Appeal Decision

Appeal Ref: 6001688

205 Harefield Road, Hillingdon, Uxbridge UB8 1PP

- The appeal is made under section 78 of the Town and Country Planning Act 1990 (as amended) against a refusal to grant planning permission.
 - The appeal is made by Mr Pabla Balbir against the decision of the Council of the London Borough of Hillingdon.
 - The application Ref is 12886/APP/2025/409.
 - The development proposed is the erection of a part single storey, part two storey side and rear extension, roof conversion to include 3 rear dormers, following the demolition of existing garage.
-

EXISTING GROUND FLOOR PLAN
scale:- 1:100@A1

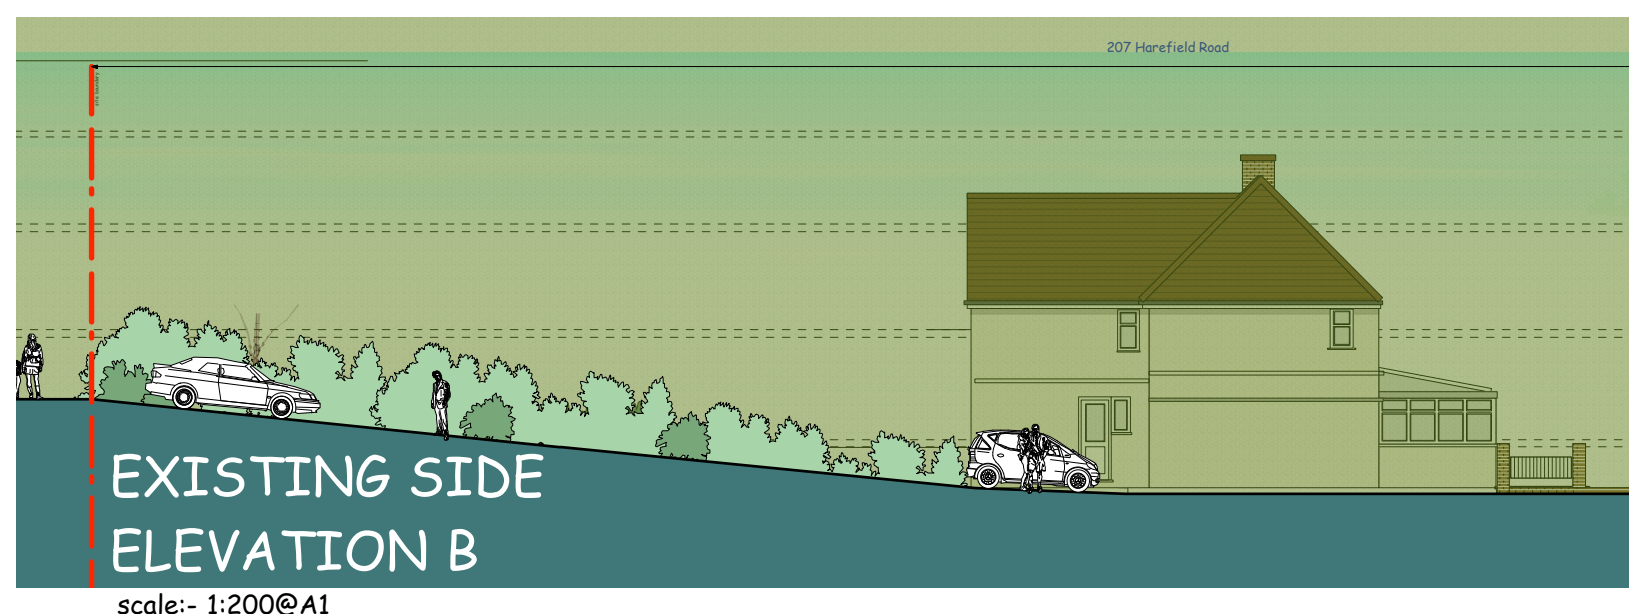
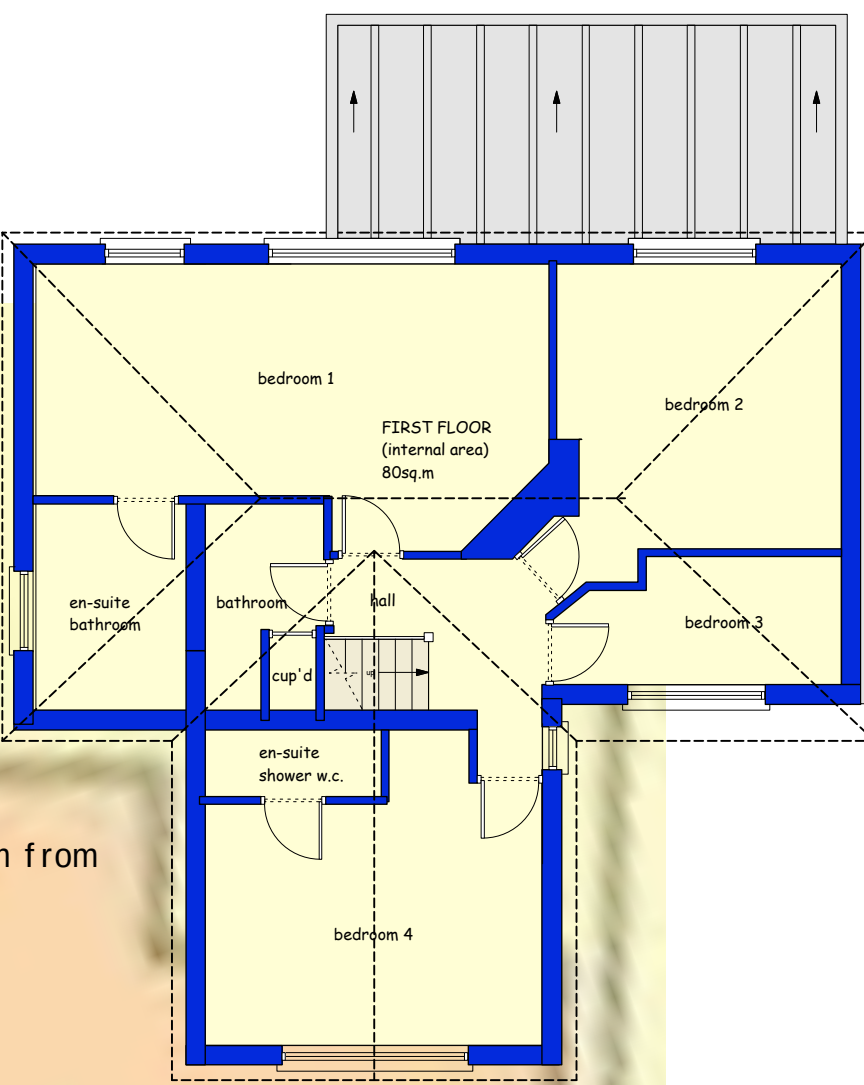
6. The existing configuration means that No 207 is sited further forward towards the highway than the appeal dwelling and as such, the side elevation of the latter is highly visible from the rear windows and garden of No 207. However, due to the single storey garage, the main bulk of the existing appeal dwelling is set away from this shared boundary. As a result, the occupants of No 207 currently enjoy a largely unimpeded outlook from their rear windows.

PROPOSED SIDE
ELEVATION D
scale:- 1:200@A1

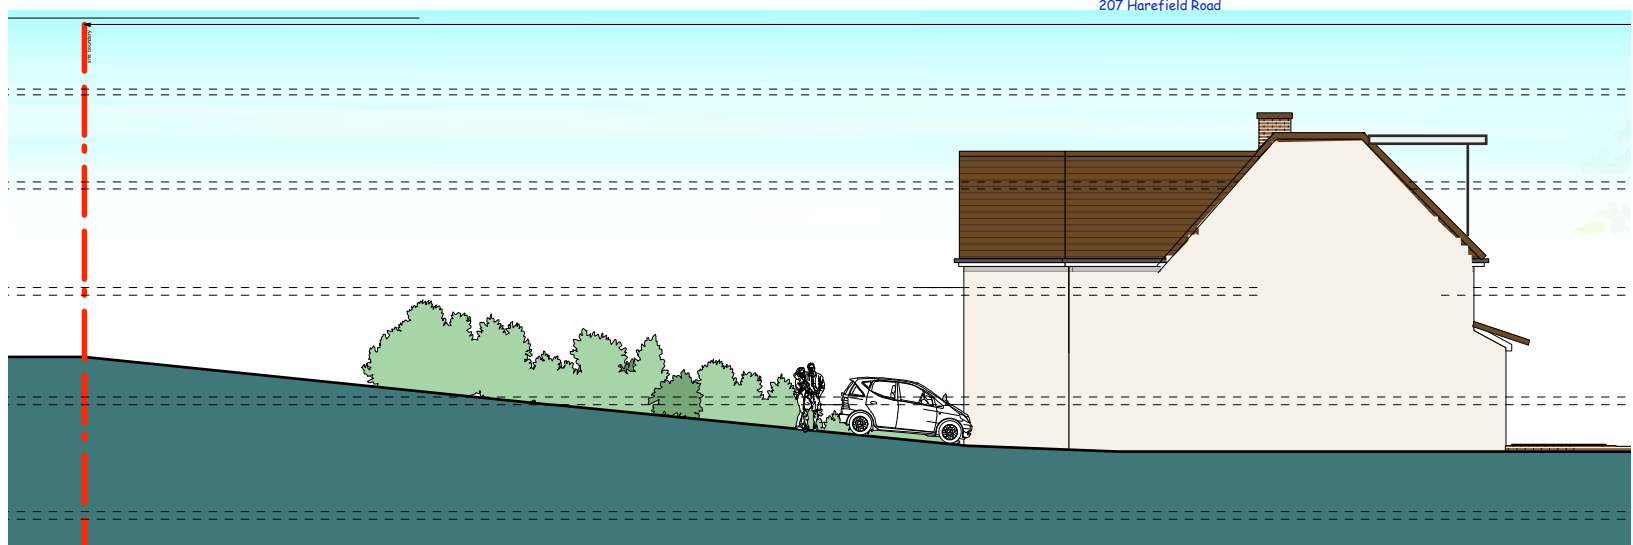
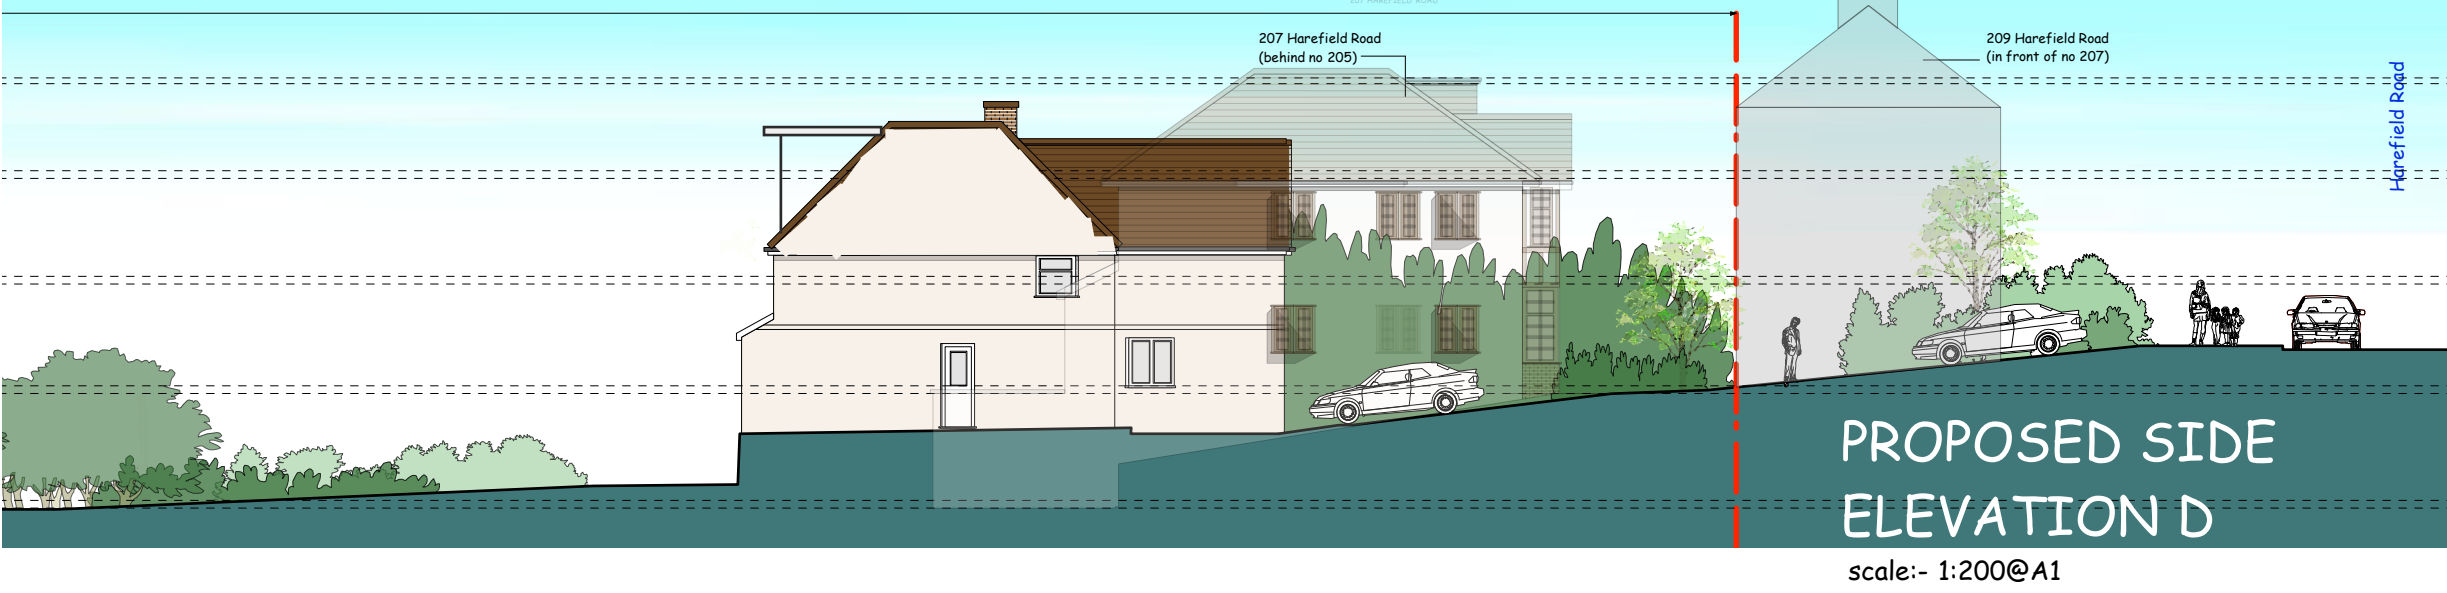
7. The proposed development would introduce a substantial two storey form in close proximity to the shared boundary with No 207. Owing to its depth and proximity to the boundary, it would present as a dominant and visually intrusive feature above the existing boundary fence within views from the rear windows of No. 207, including the conservatory.

9. Given the proposed scale and its proximity to the shared boundary, together with the site configuration that places the appeal dwelling to the south of No. 207, the garden area closest to No 207 and the windows nearest to the development would be very likely to experience additional overshadowing beyond current conditions. On the basis of the information before me, it cannot be established that those effects would be acceptable.

10. The proposal would also extend beyond the front elevation of the existing garage, aligning approximately with the middle and first floor oriel windows on the side elevation of No 207. Due to its height and close positioning, the proposal would appear as a dominant feature in views from these side windows, creating an increased sense of enclosure. These windows, however, appear to serve secondary functions, with the associated rooms benefitting from primary outlook through other front and rear facing windows. Although the proposal would reduce the outlook from the oriel windows, this effect alone would not amount to an unacceptable impact on the living conditions of the occupants of No 207.

Appendix 4 Tree Constraints Plan

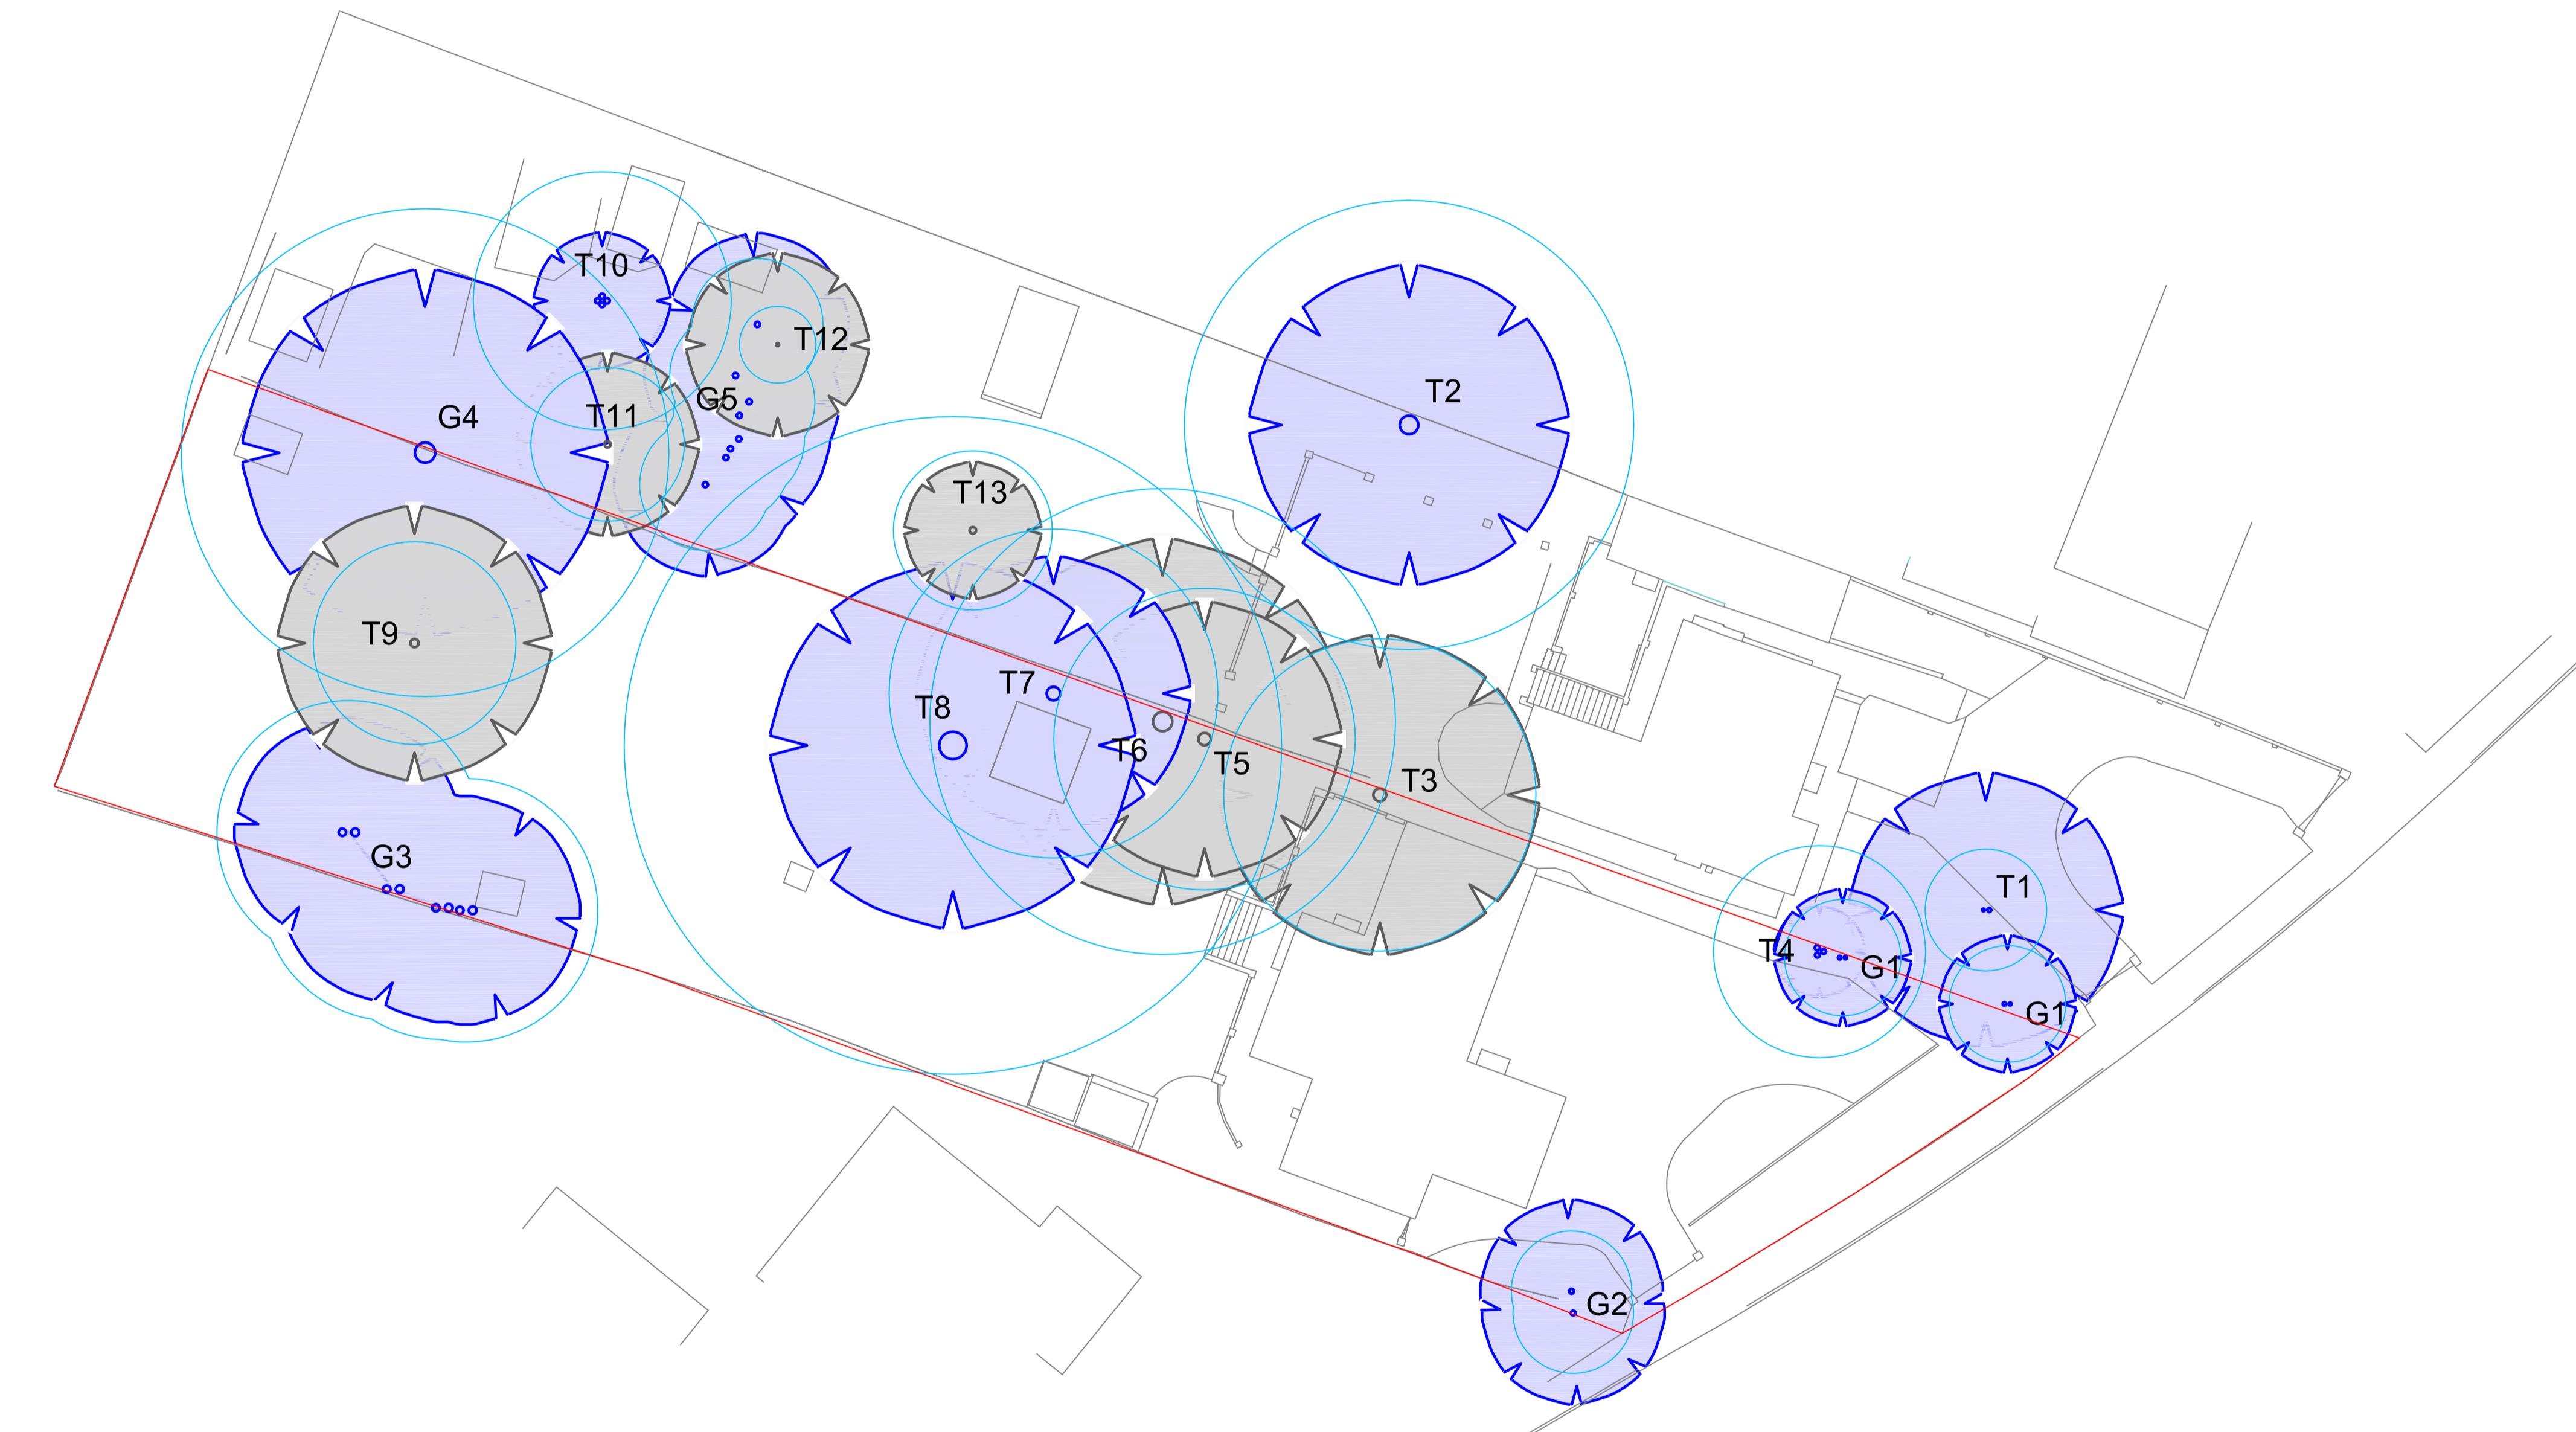
15. Despite this, it was observed at the site visit that a number of trees within the rear garden (T3, T5, and T6 as shown on plan P2906B) had already been removed. I understand the felled trees also included trees T8 and T9, which had been earmarked for retention. On this basis alone the submitted AIA is clearly inaccurate as a technical document supporting the proposed development.
